From: [BT Email](#)
To: [Planning Comments \(Shared Mailbox\)](#)
Subject: Reference: 6/2022/2586/HOUSE 61 The Ridgeway, ENG 4BD
Date: 08 December 2022 16:49:28

We write with major concerns with respect to the closeness and impact of the proposed extension to the front of the property and would ask for your clarification of various points of issue as set out below.

GROUND FLOOR PLAN 1:50

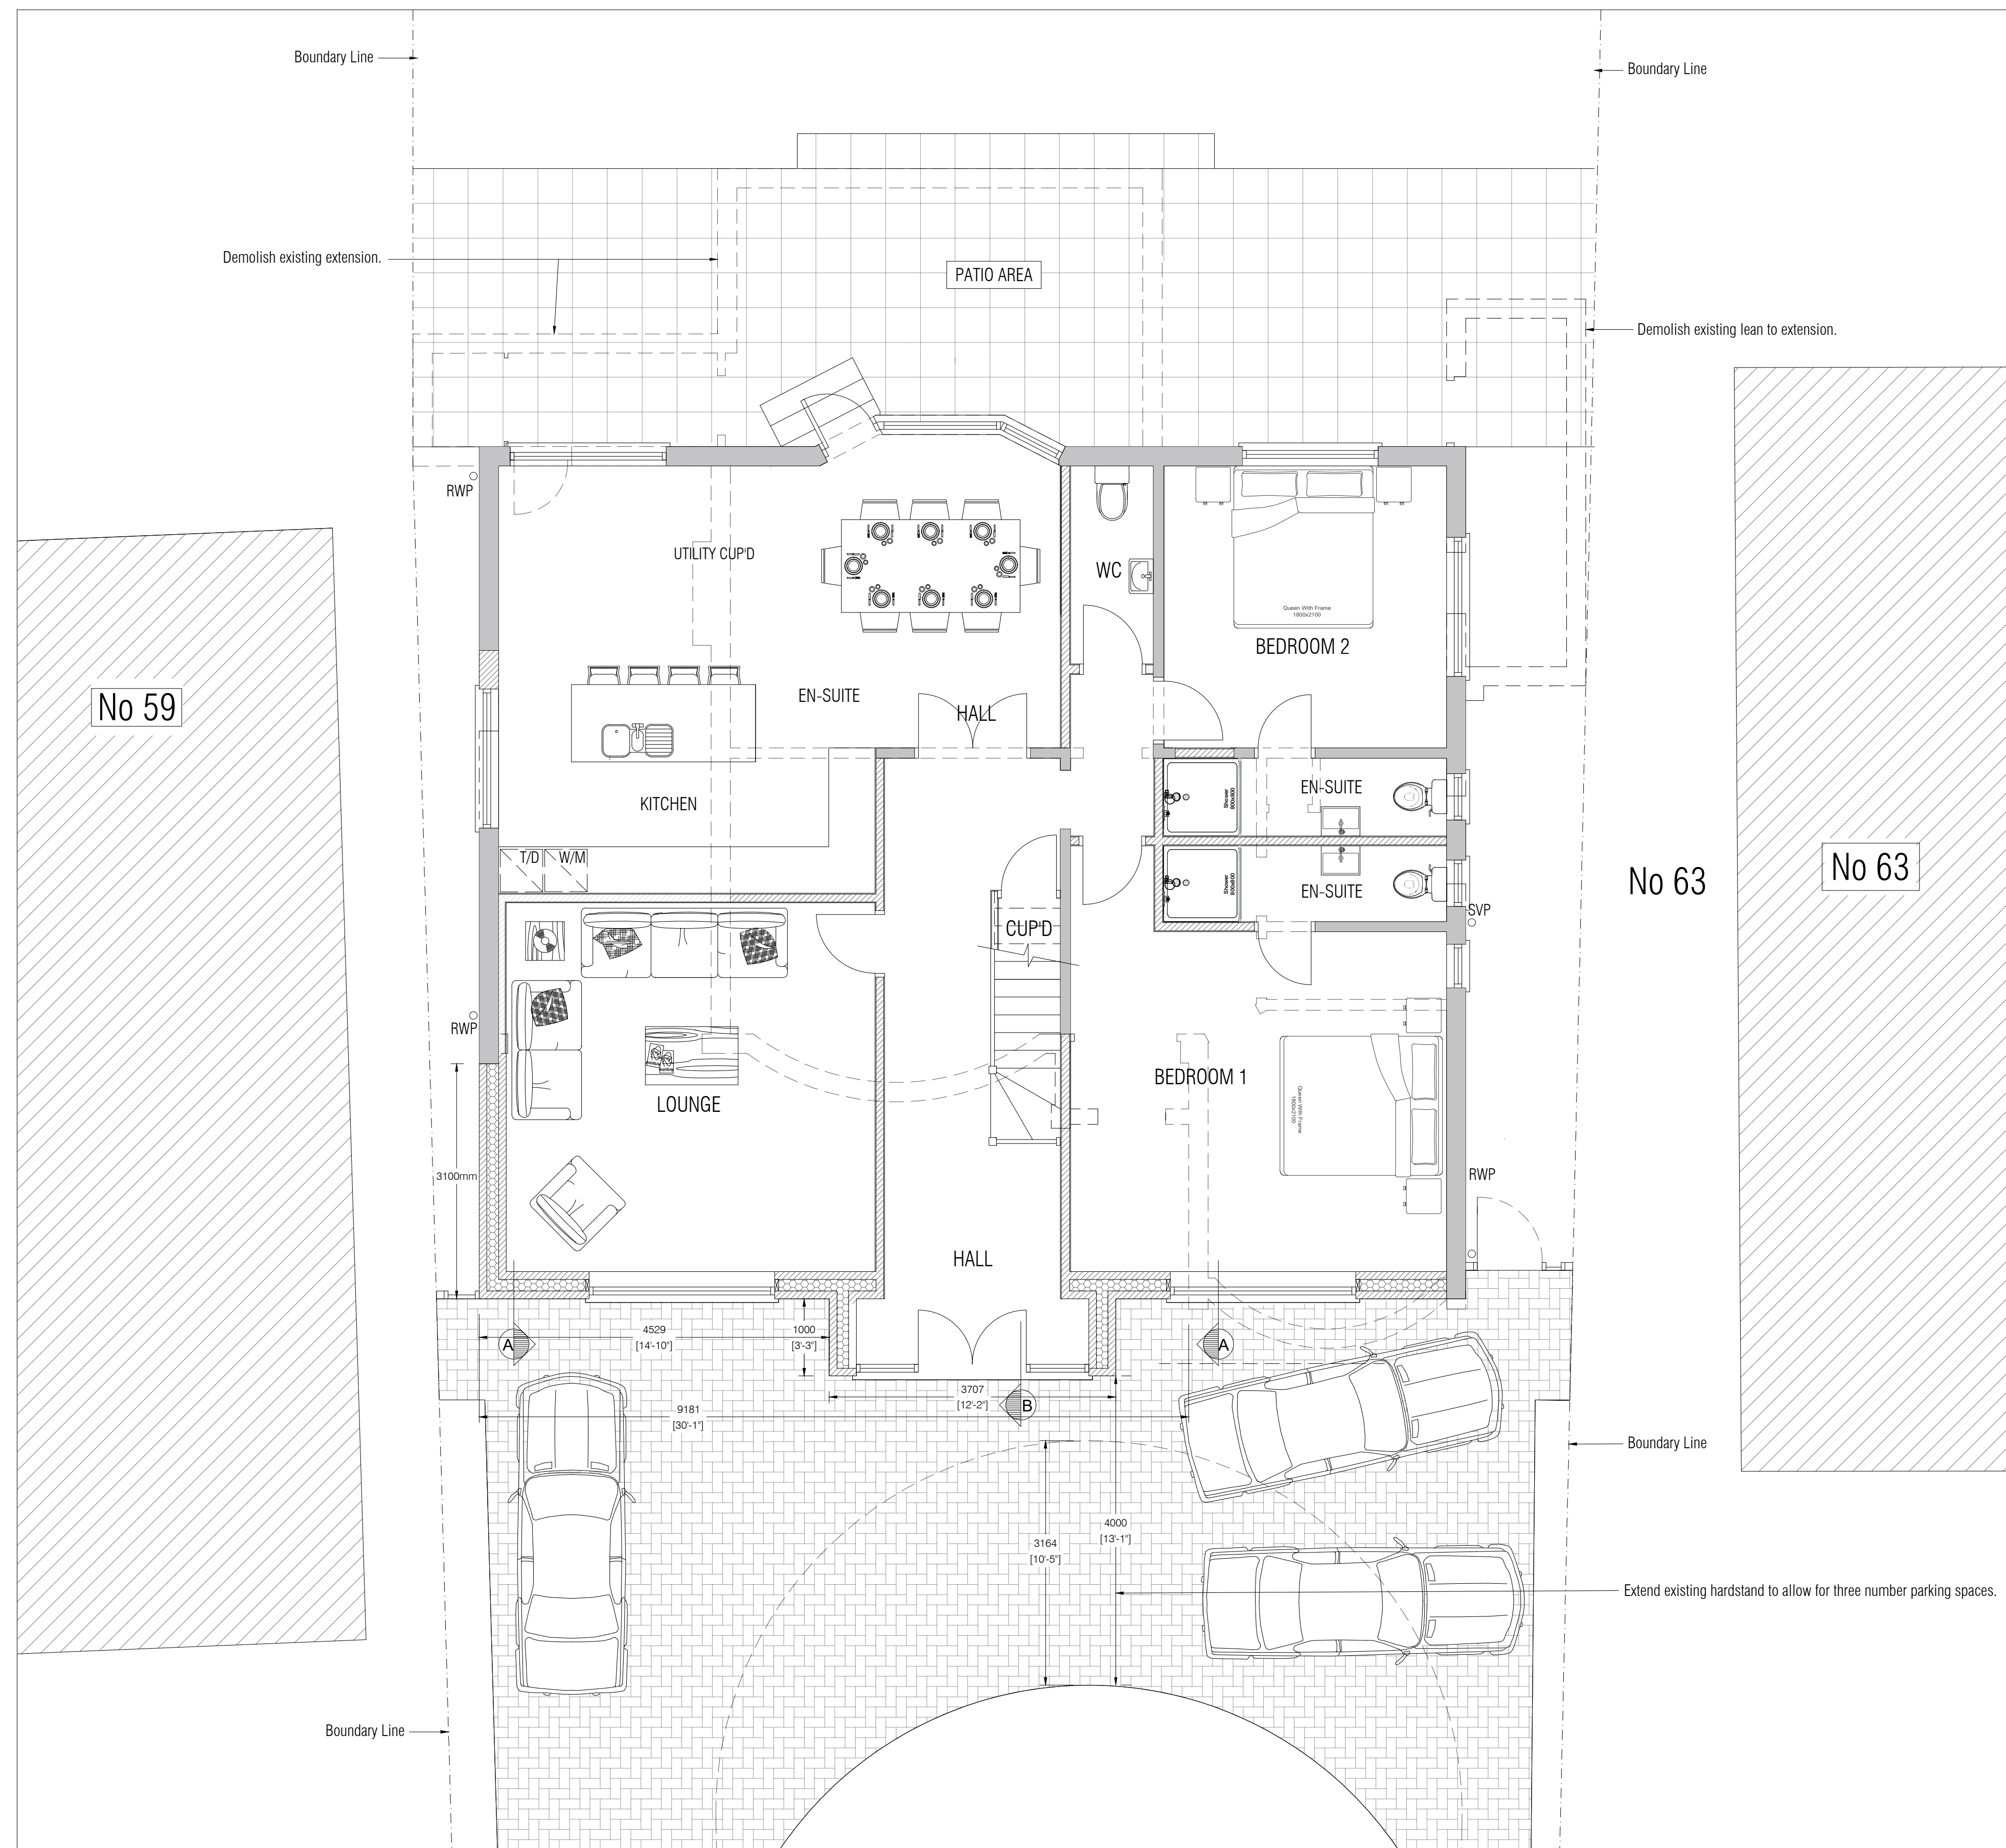
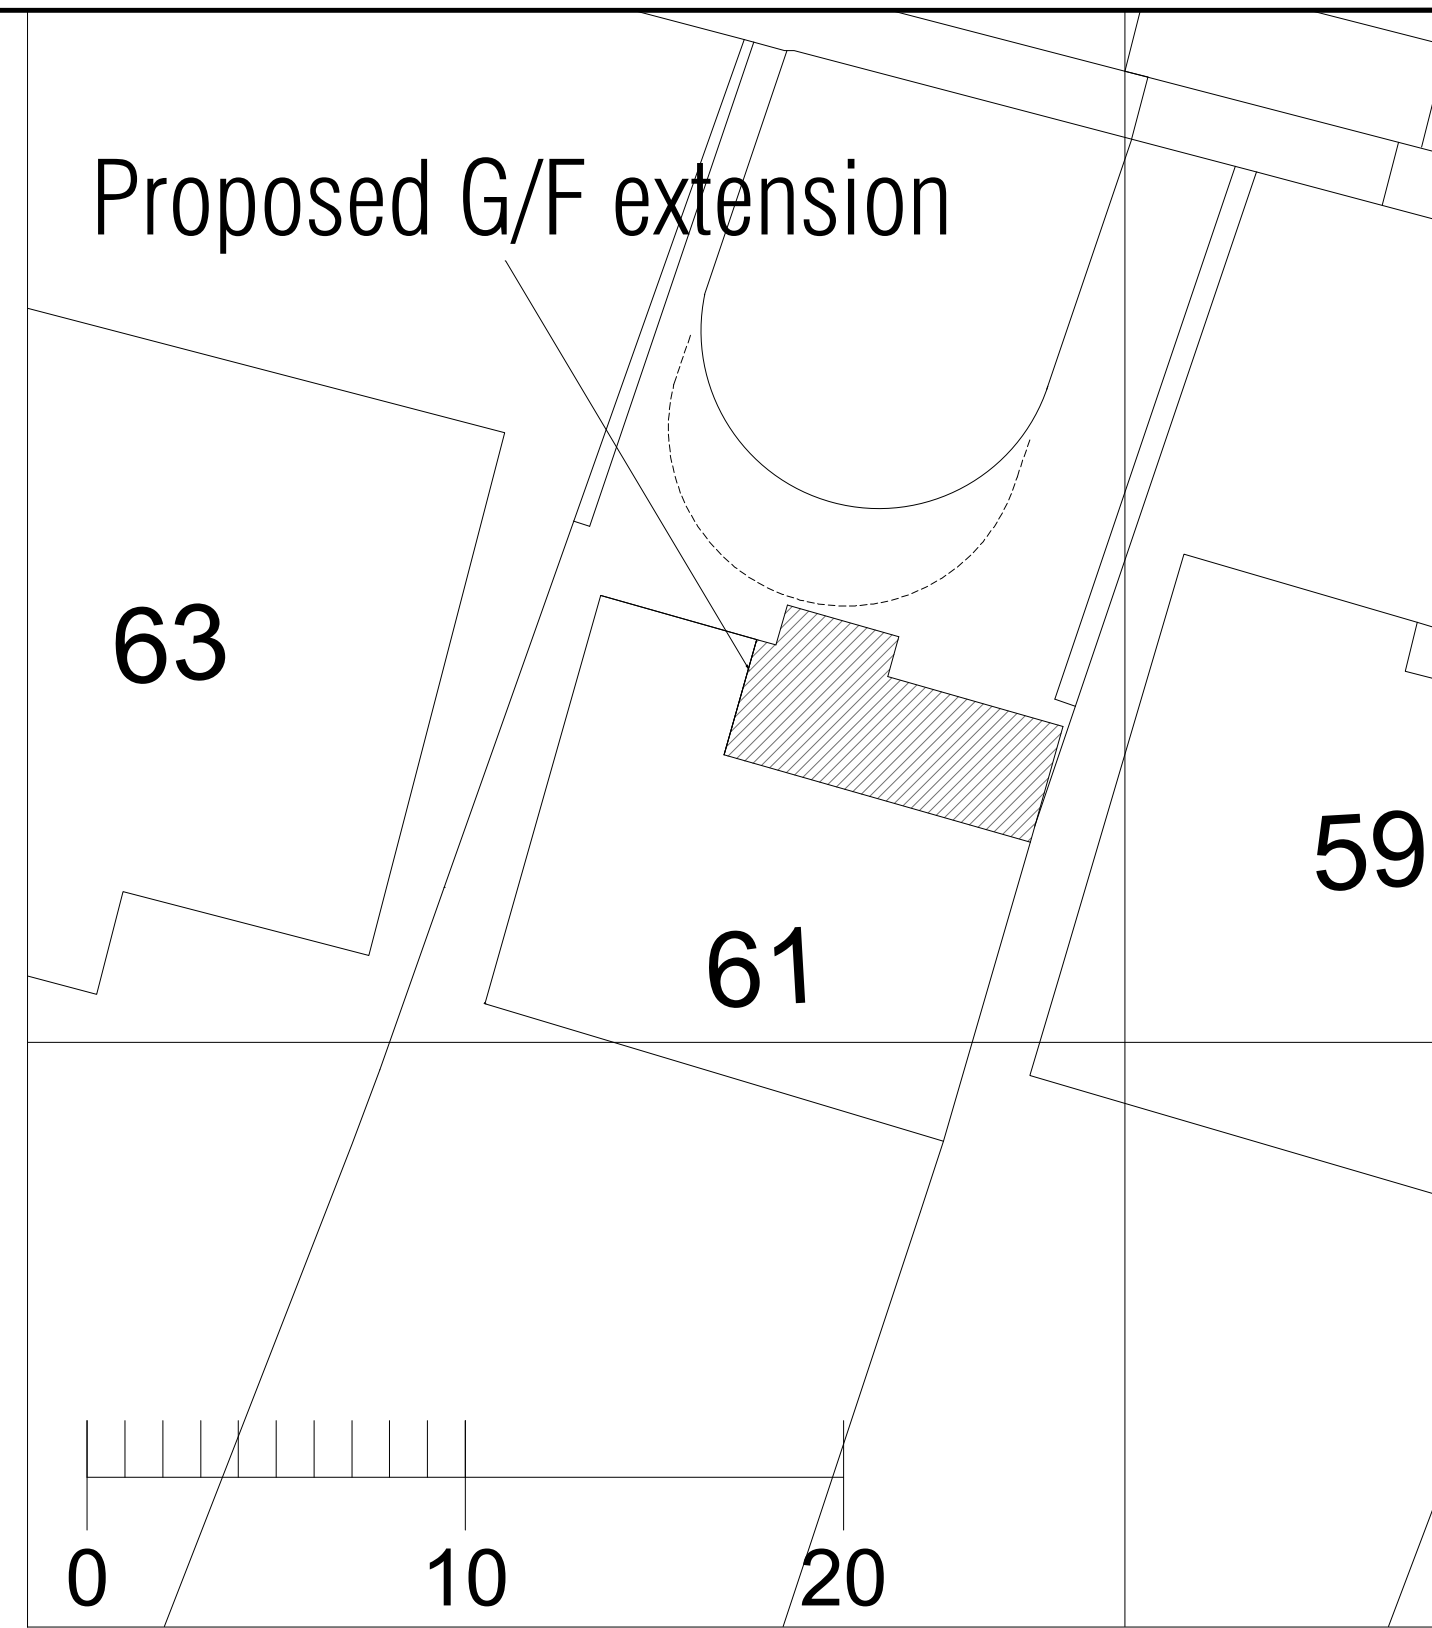
The actual boundary tapers towards the front and is not parallel as drawing detail, at present the brick fabric is 800mm from the centre line of the boundary at the rear, and 590mm at the front (garage) with present soffit/facia/guttering being 605mm hence already overhanging the boundary to the front. Once the extension is added of 2.335mm as detailed on drawing (103) this will create a greater overhang of the boundary, existing timber fence panels are virtually impossible to remove.

The actual extension size specified of 2.335mm does not correspond with the proposed removal of the front bay window and thereafter to continue the building line across to the garage side, the existing porch being set back by some 770mm (overlooked) will mean the extension will actually be 3.100mm, even move boundary overhang if this is to be the case and would fully block out the light to our utility room and probably reduce the light into our family room especially if the greater dimension is approved?
